DORAN DRIVE PLAZA PRECINCT SHOWGROUND

RESPONSE TO STATE DESIGN REVIEW PANEL COMMENTS

DEICORP PROJECTS (SHOWGROUND) PTY LTD

MAY 2021

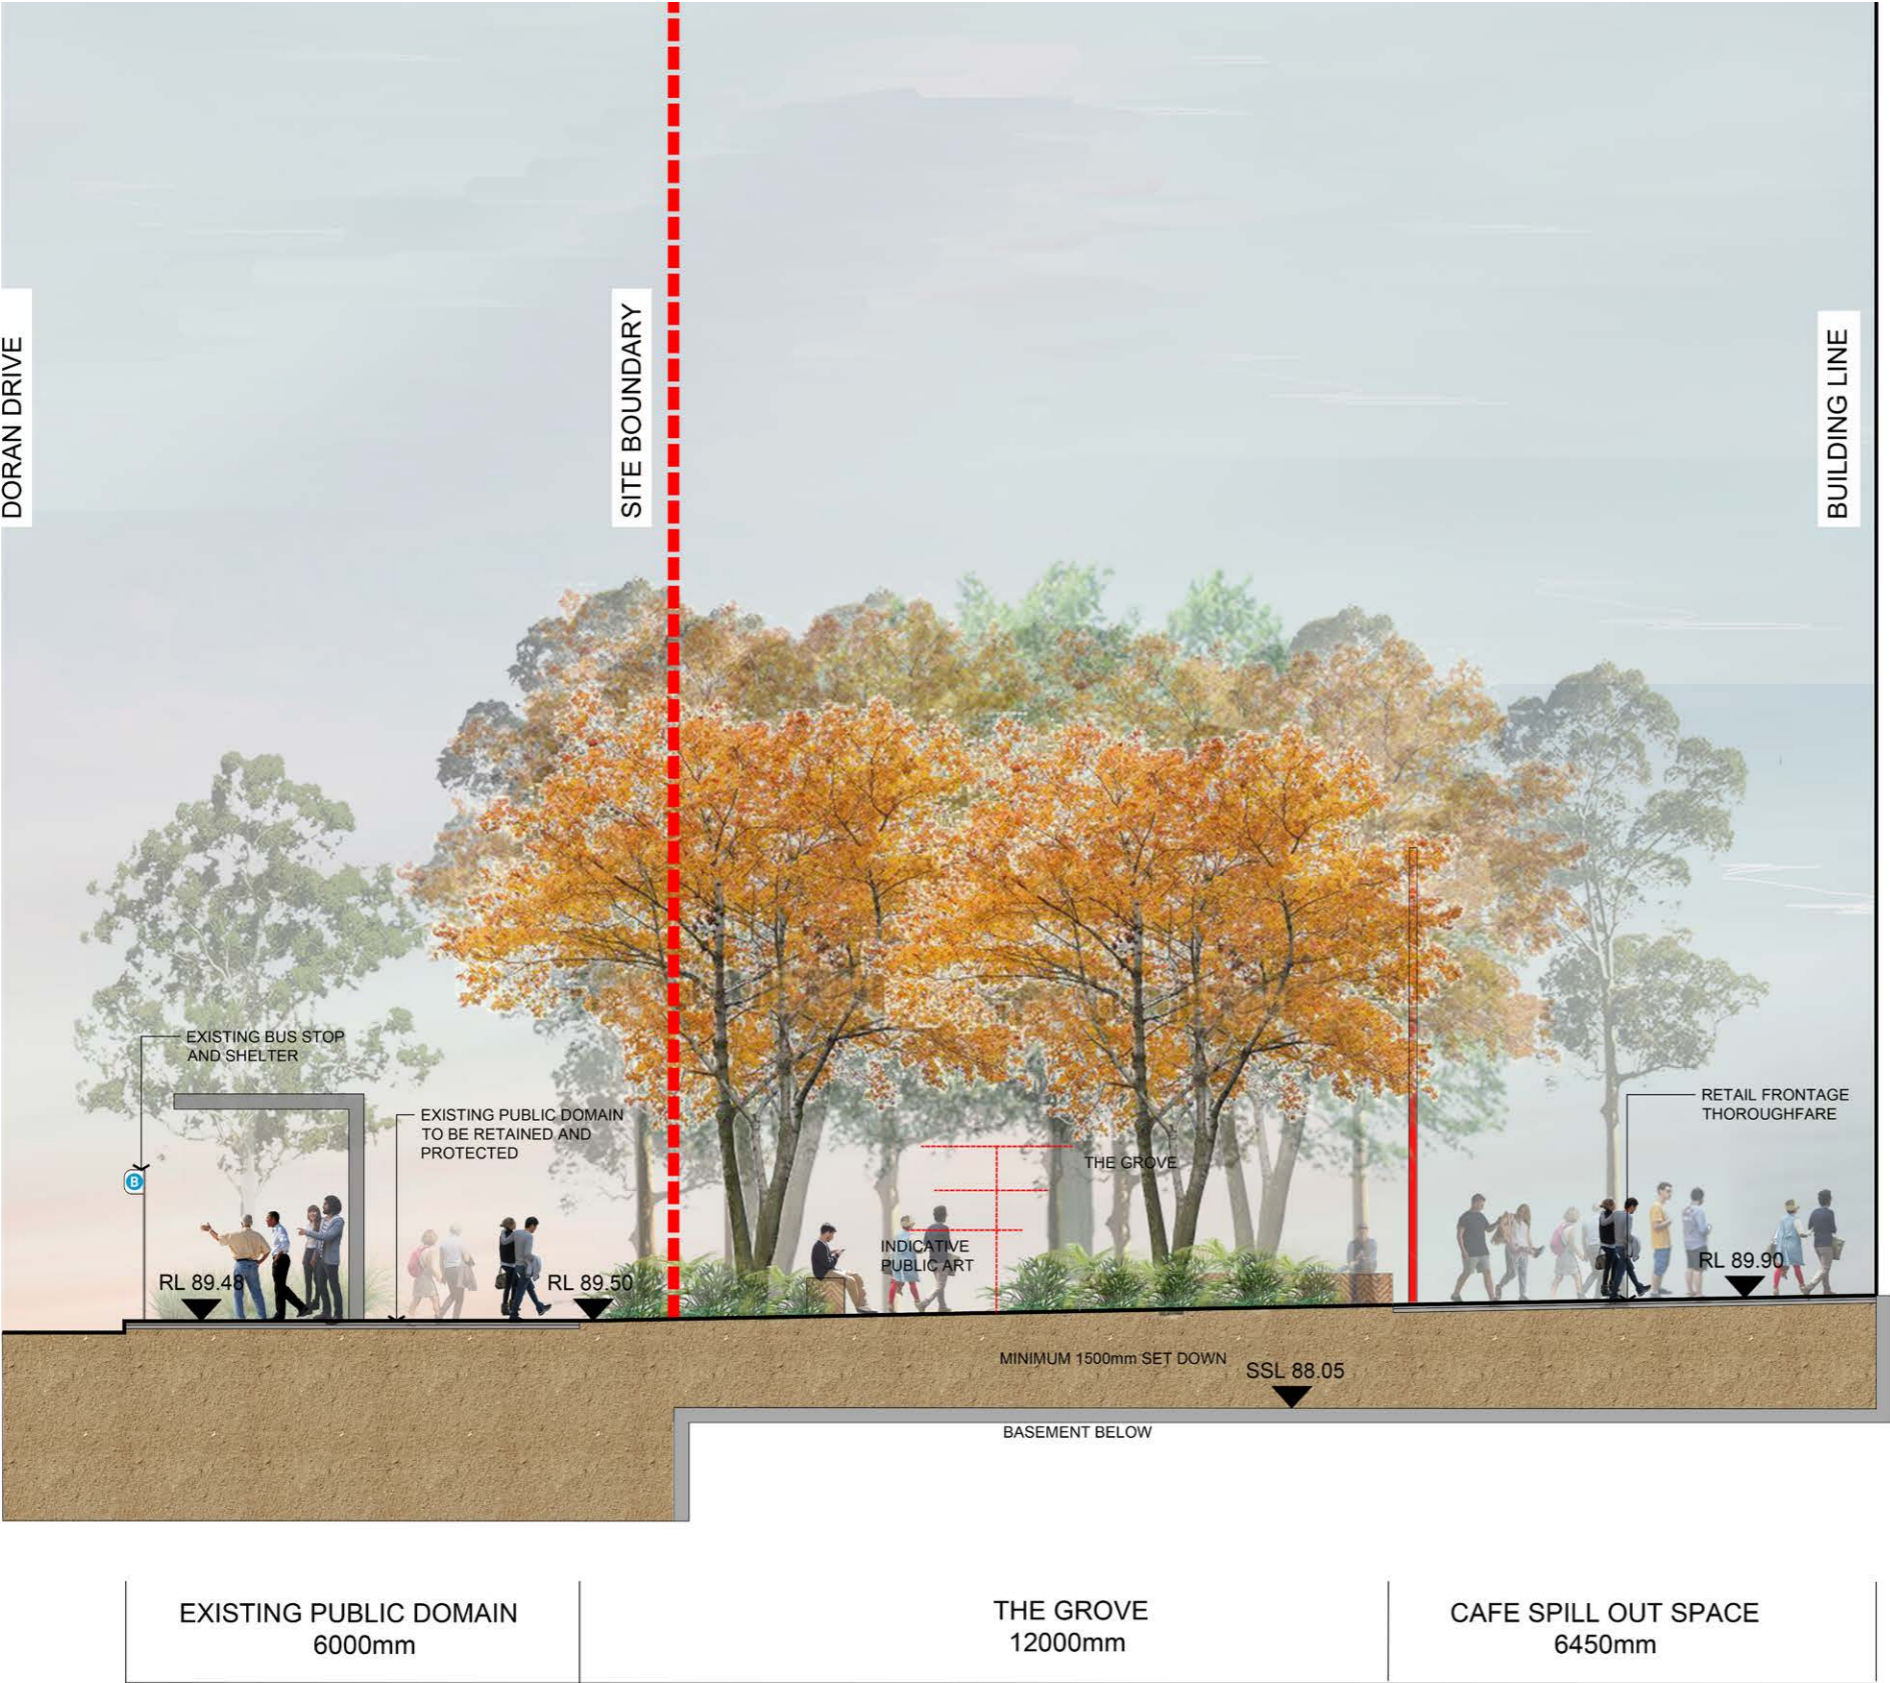
2. MASTERPLAN / PUBLIC SPACE – Doran Drive Plaza		
<p>2.1</p> <p><i>The public domain plan should be updated to show adjacent context - including the correct location of pedestrian crossings as well as areas adjacent to the sub precinct boundaries e.g., the opposite sides of the street and the entry point into the showgrounds.</i></p>	<p>Urbis Charlie Robinson <i>Registered Landscape Architect #5895 (AILA)</i></p>	<p>Architectural site plan have been updated to match landscape showing correct pedestrian crossings – Please refer to architectural context plans including well as areas adjacent to the sub precinct boundaries e.g., the opposite sides of the street and the entry point into the showgrounds.</p>
<p>2.2</p> <p><i>The single level of Doran Drive Plaza and the amphitheatre to the north obstructs pedestrian flows from the Metro to the Showground and requires further consideration to resolve visibility, universal access and permeability for this significant open space.</i></p>	<p>Urbis Charlie Robinson <i>Registered Landscape Architect #5895 (AILA)</i></p>	<p>De Clambe is already built and has a cross fall of 1:20 – we are working with these levels to create an accessible and activated public domain that clearly links the metro to the crossing points and wider precinct with a 3m wide path – Plans have been updated to further improve site permeability.</p>

<p>2.3</p> <p><i>Outdoor dining areas fully occupy the footpath zone along the western frontage. This sheltered space should be prioritised for pedestrian use. 5m</i></p>	<p>Urbis Charlie Robinson <i>Registered Landscape Architect #5895 (AILA)</i></p>	<p>Plan updated to reflect an additional 1m set back – giving 6m to the building interface to allow for further improved pedestrian circulation.</p>
